SKP-18-004

SKETCH PLAN
MEADOWLAKE RANCH

Reference: Meadowlake Ranch Sketch Plan, Project File No. SKP184

We have reviewed the revised Letter of Intent posted on January 7<sup>th</sup>, 2019 and the revised Sketch Plan posted on January 14<sup>th</sup>, 2019 at the El Paso County Development Application Review website for this project.

SKETCH PLAN

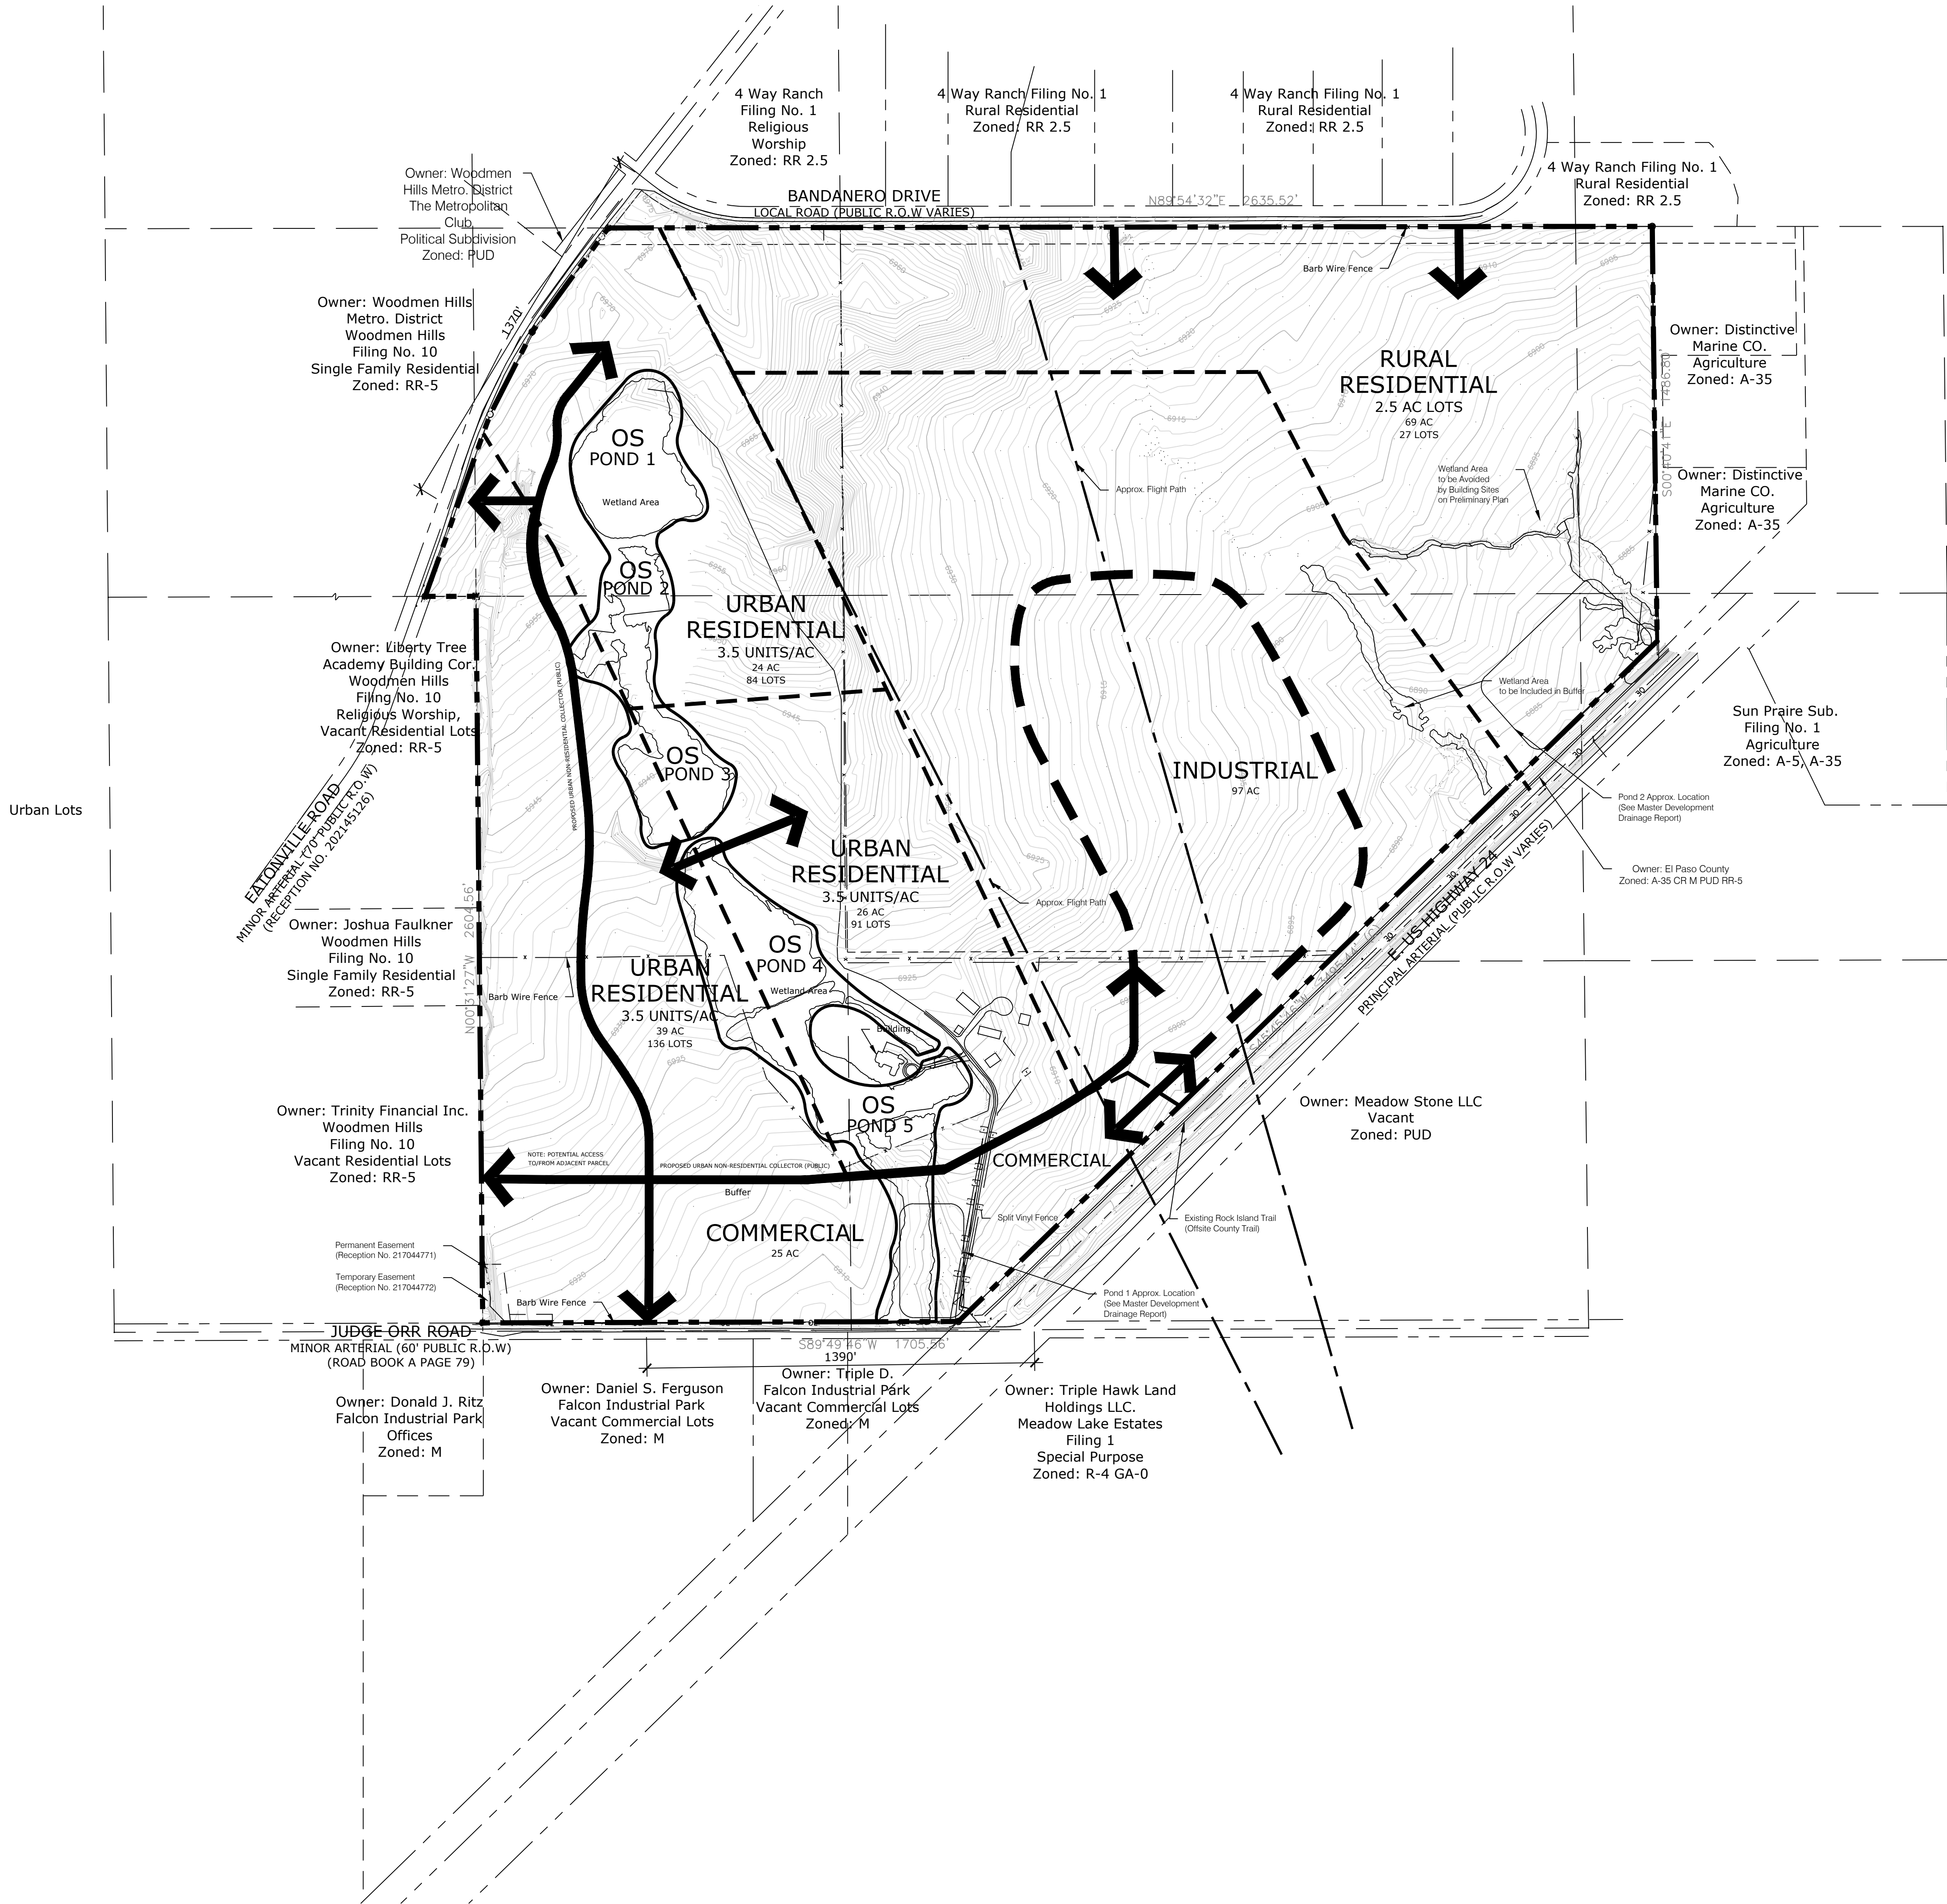
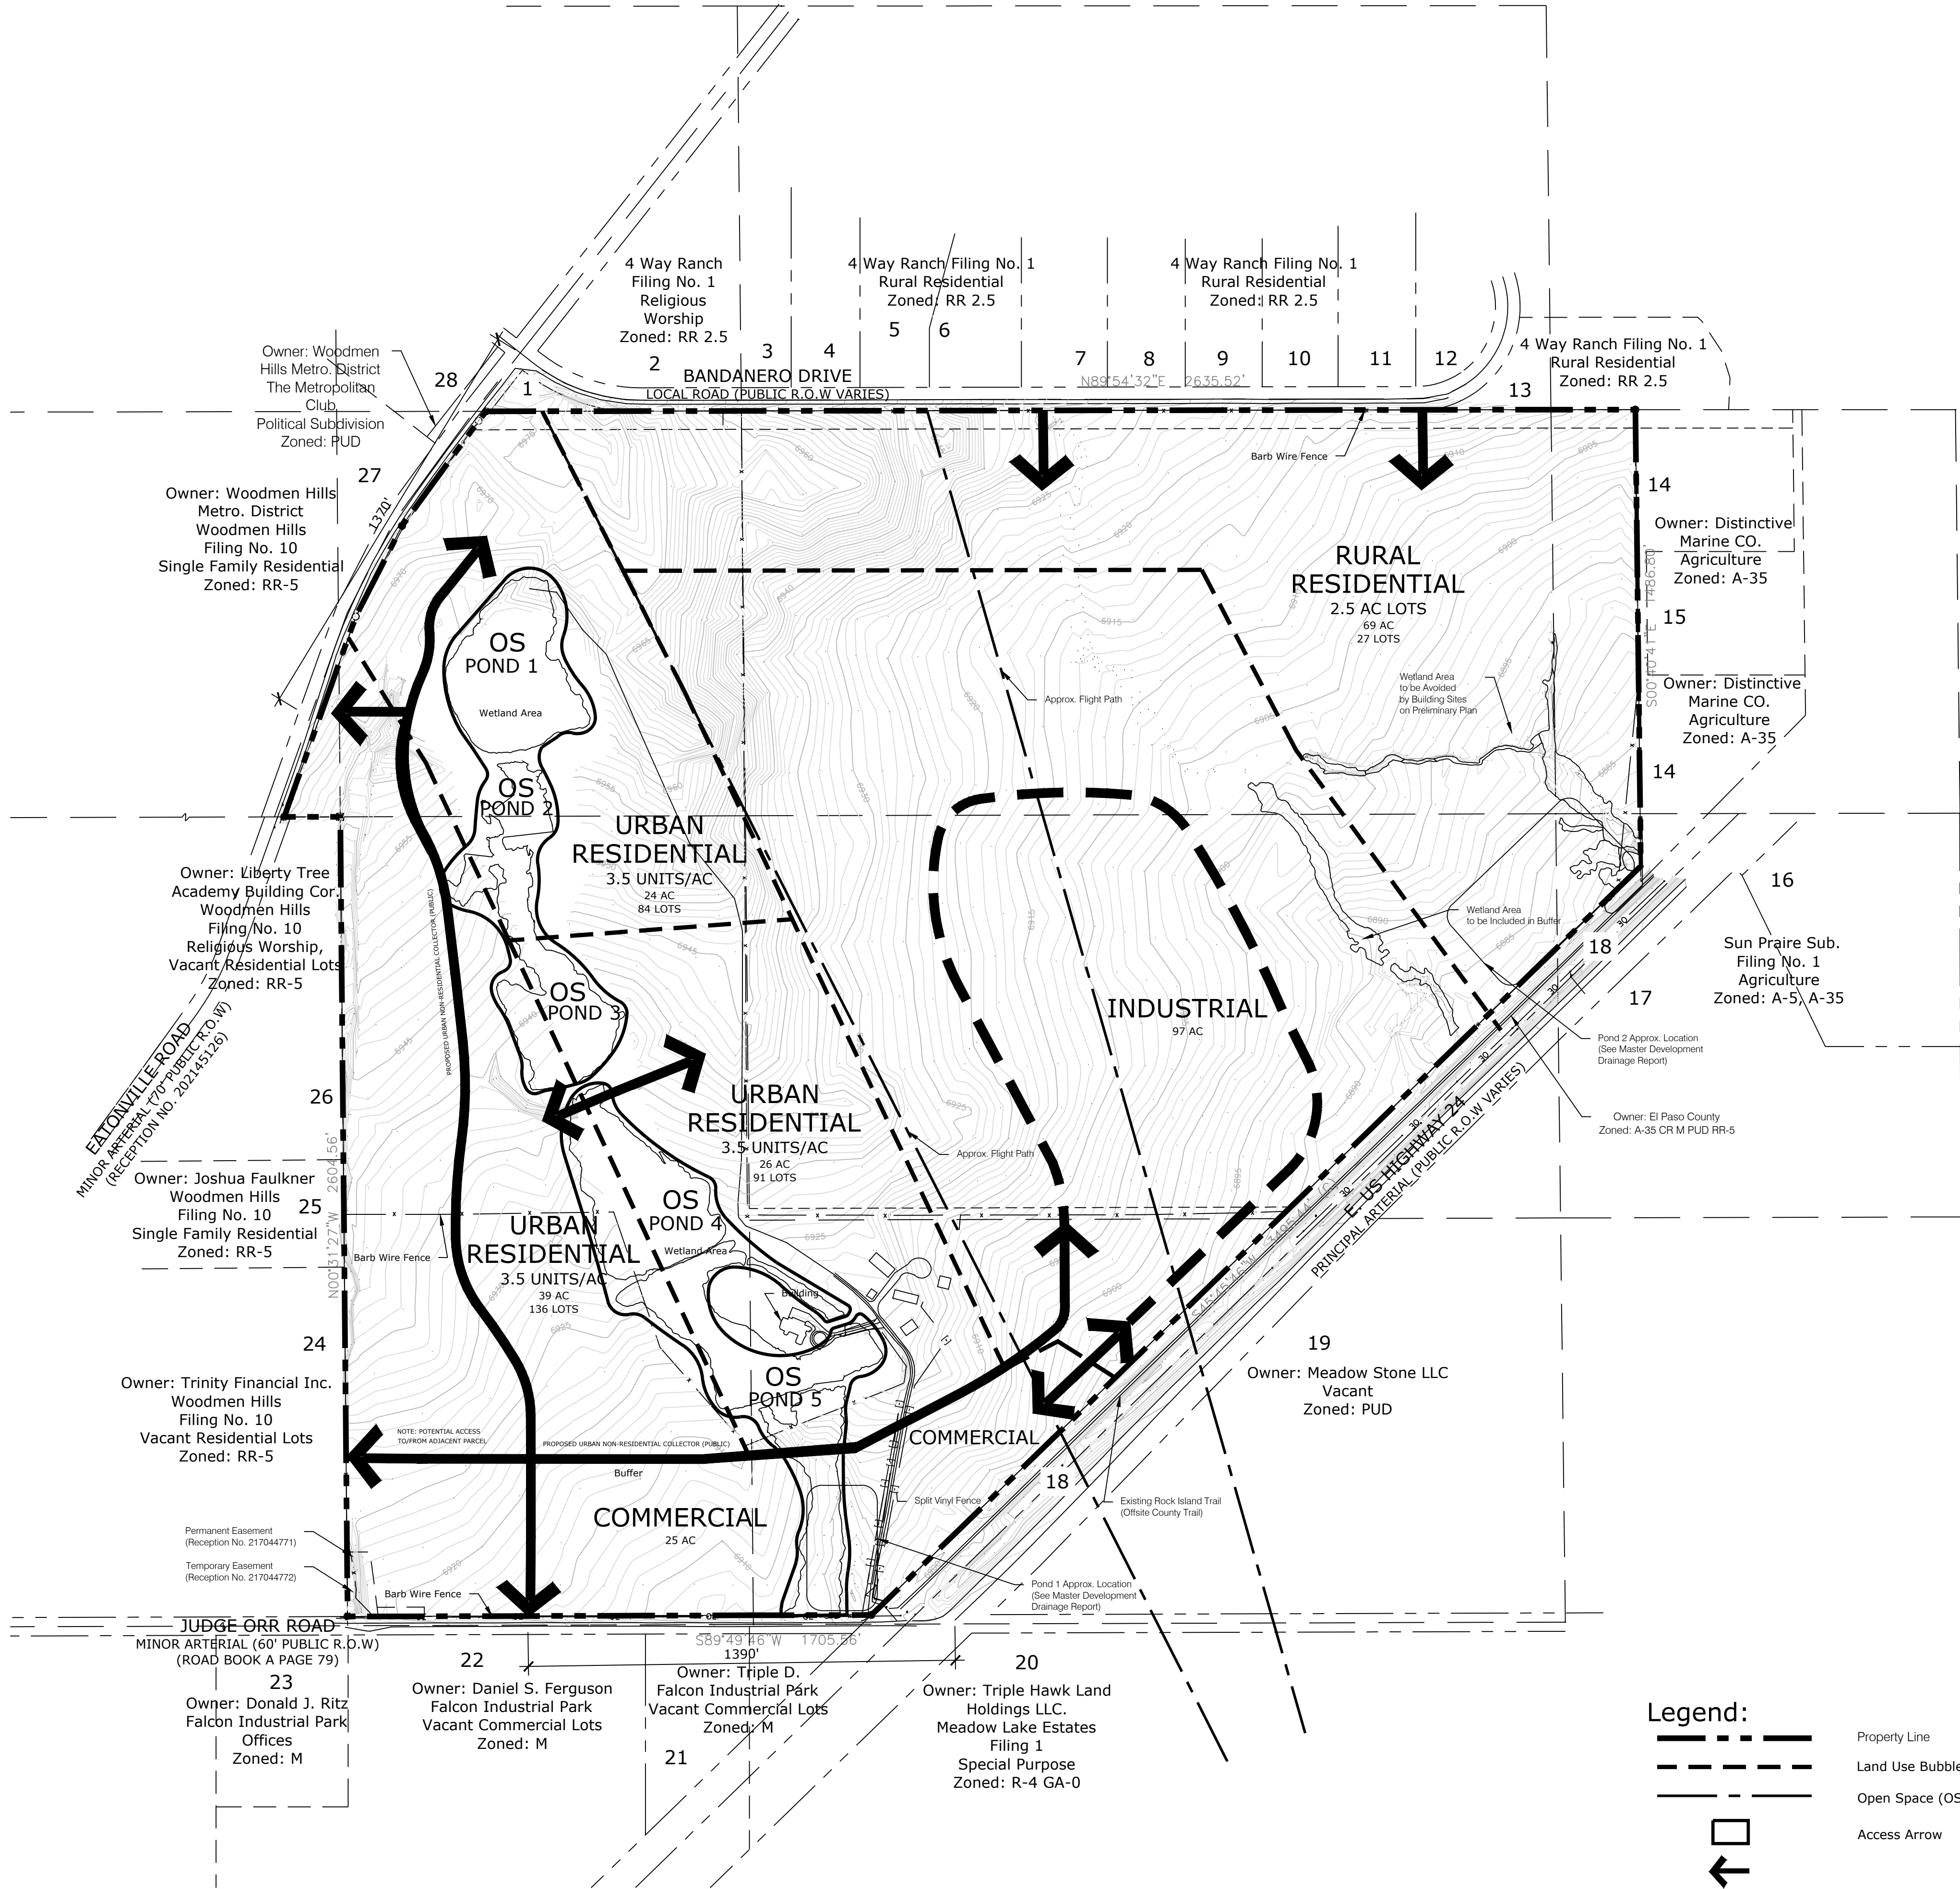
The revised sketch plan expands the proposed Industrial use area in a northerly direction as compared to the previous sketch plan. See Attachments A and B. The sketch plan is drawn to scale and indicates that the boundary of the Industrial use area will be less than 600 feet from properties on the north side of Bandanero Drive. We own and live at one of those properties.

We contend that the quantity of Industrial use area (58 acres or 19% of the development) and the close proximity of proposed Industrial use area to Residential use area not only fails to comply with this plan goal, but actually violates the goal. Contrary to the statement in the Letter of Intent, there are no nearby Industrial uses in either the Woodman Hills or 4-Way Ranch Metropolitan Districts No. 1.

We contend that the close proximity of proposed Industrial use area to Residential use area not only fails to comply with this plan goal, but actually violates the goal. It is not the objective of paragraph 4.5.2.1 to encourage close proximity of Industrial and Residential uses. Mixed non-residential use is normally understood to exclude Industrial use.

- Paragraph 6.1.8 - Encourage incorporating buffers or transitions between areas of varying use or density where possible.
- Paragraph 6.1.9 - Viable residential properties should be reasonably protected from the adverse impacts of major roadways and other potentially incompatible land uses.
- Paragraph 6.2.8 - Clearly defined boundaries should be established for large institutional, industrial, and commercial areas and used in order to protect the integrity of established and developing neighborhoods.

- Paragraph 4.5.1.6 - Avoid hard-line boundaries between designated areas for particular uses and densities unless there are sub-area characteristics that support these boundaries.

We object to the extension of the Industrial use are to the north.
